**Our ref:** WA/2019/126852/01-L01  
**Your ref:** TR010030

**Date:** 6 September 2019

**Application by Highways England for an Order granting Development Consent for the M25 junction 10/A3 Wisley interchange improvement**

## **Relevant Representations On behalf of the Environment Agency**

**Figure 2.1: Environment Agency Flood Zone mapping and watercourse location plan**

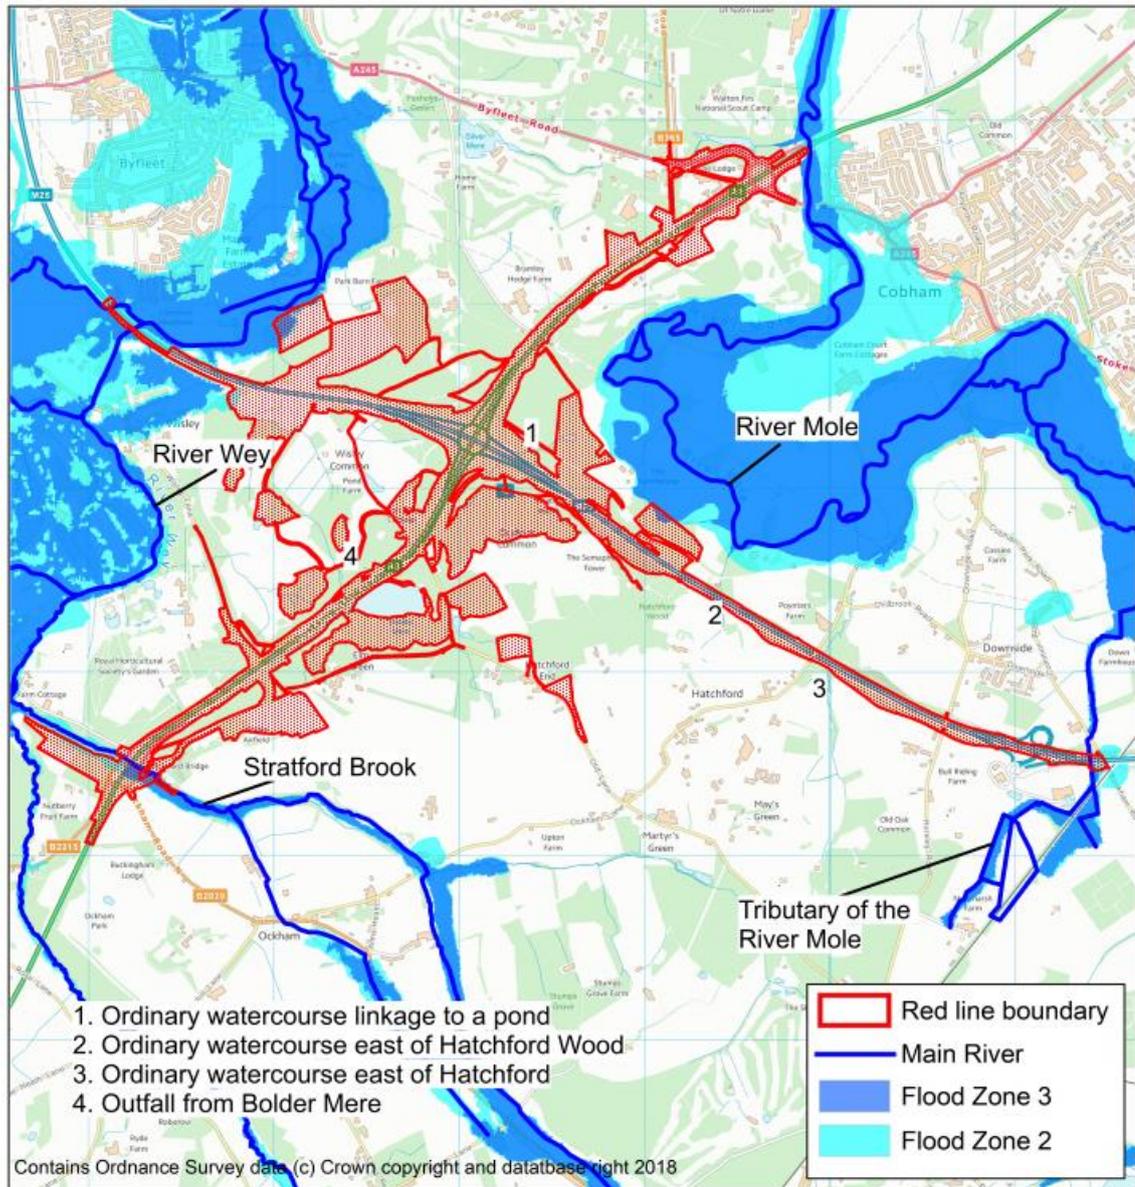
- 2.1 Our main flood risk concerns are with works on and adjacent to the Stratford Brook (in the River Wey catchment) to the south-west of the scheme. This work includes a new road bridge over the Stratford Brook, works to/around culverts under the A3 and a construction compound in an area of flood risk.

- 2.3 Due to apparent shortcomings, it is difficult for us to wholly agree with the conclusions of the Flood Risk Assessment (FRA) (reference: TR010030/APP/5.5) that "...*the proposed Scheme, with the incorporation of flood risk mitigation/considerations...is considered acceptable from a flood risk perspective.*" because of in the report. Further information is required for us to support this conclusion.

- 2.4 Of particular concern to us following a review of the FRA are a lack of demonstration that appropriate allowances for climate change have been considered, unclear terminology in places, and a number of assumptions made without supporting evidence.
